From: Polly Harris-Gorf
Sent: 11 June 2020 12:24
To: _planningadvice
Subject: FW: H07-0365-20 Off Highstock Lane Gedney Hill
Attachments: We sent you safe versions of your files; 40519-Infiltration Test Results.pdf

Details of soakaway system (Condition 3 of H07-0015-20)

Sheet No. 40519/SA01					Rev -
Status FOR INFORMATION					
Date	Feb. '20	Drawn	MP	Checked	SRC
Scale	1:20	Design	-	File Name	40519-SA01

Project **Residential Development To Land Off
Highstock Lane, Gedney Hill,
Spalding, Lincs.**

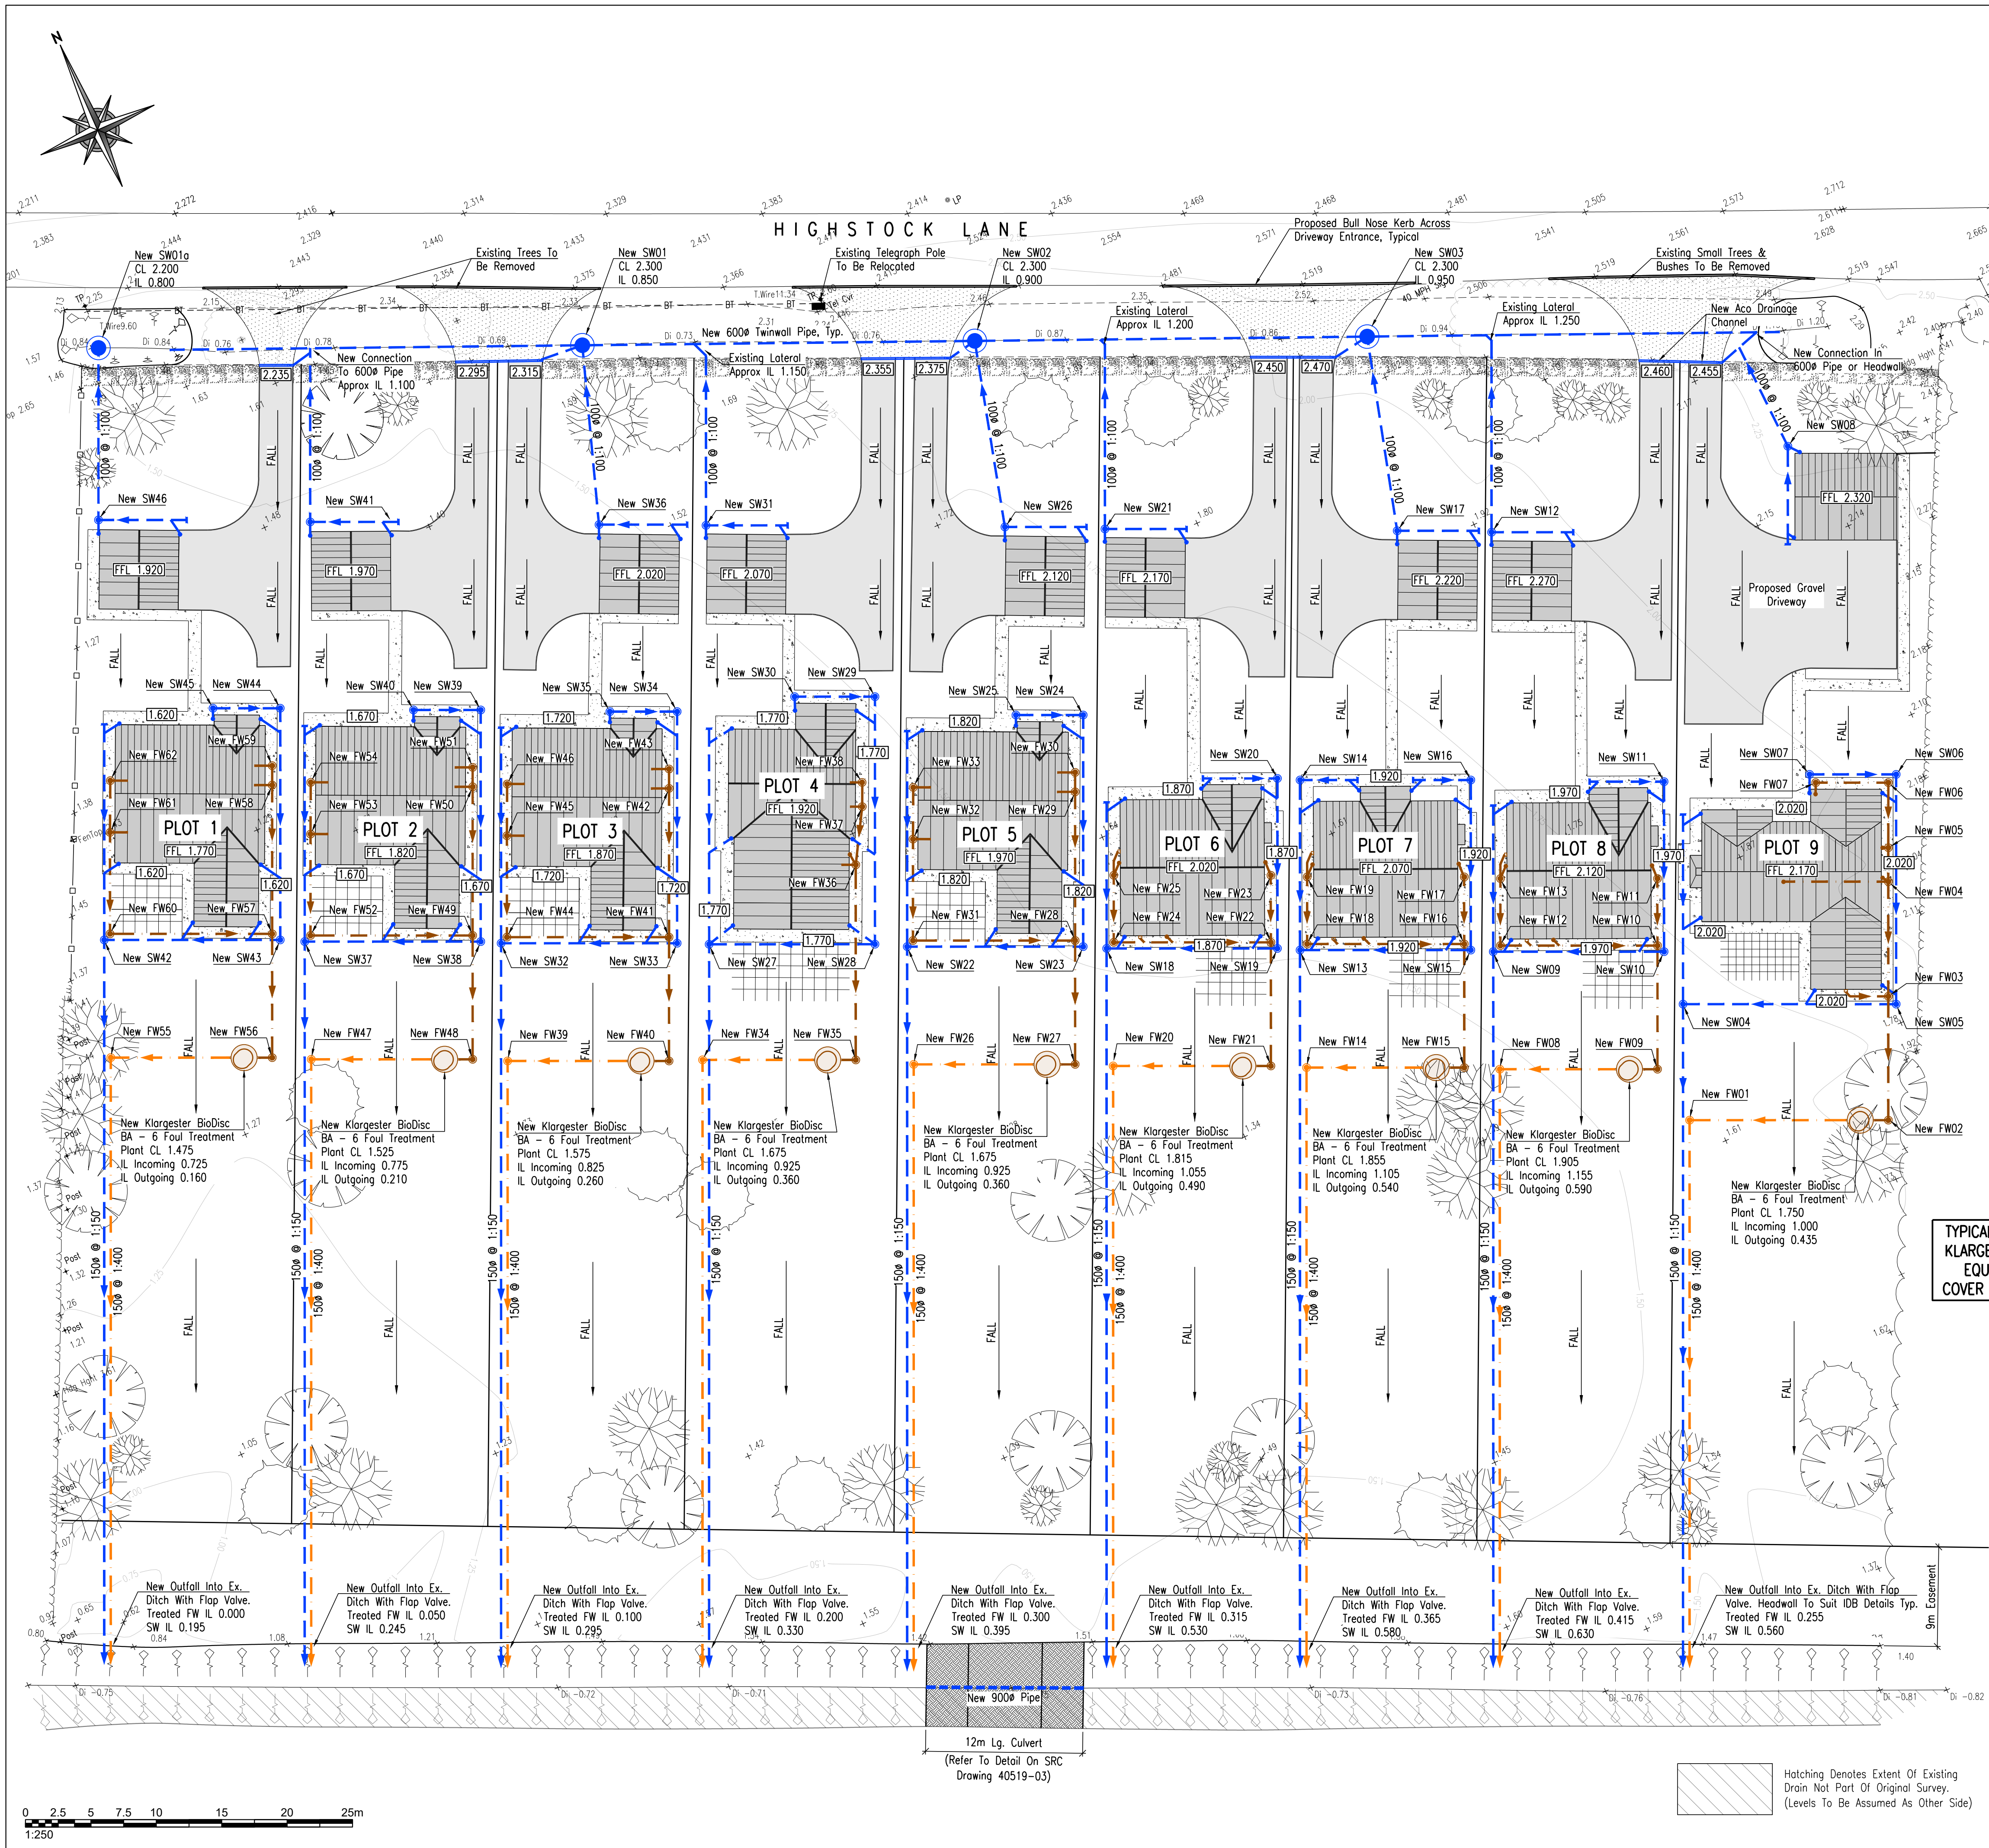
This condition makes it clear that if soakaways are not an appropriate form of drainage, then an alternative means of providing for surface water drainage shall be submitted for consideration, however you have jumped a stage of this and not provided me with the evidence that soakaways would not work on this site. Please can you provide me with the evidence that soakaways have been considered and the reasons and evidence for discounting this as a method.

Also, I have received the views of the Internal Drainage Board and LCC Highways and SUDS, the latter raising issues. These can be viewed in the usual way at the following link
<https://planning.sholland.gov.uk/OcellaWeb/showDocuments?reference=H07-0365-20&module=pl>
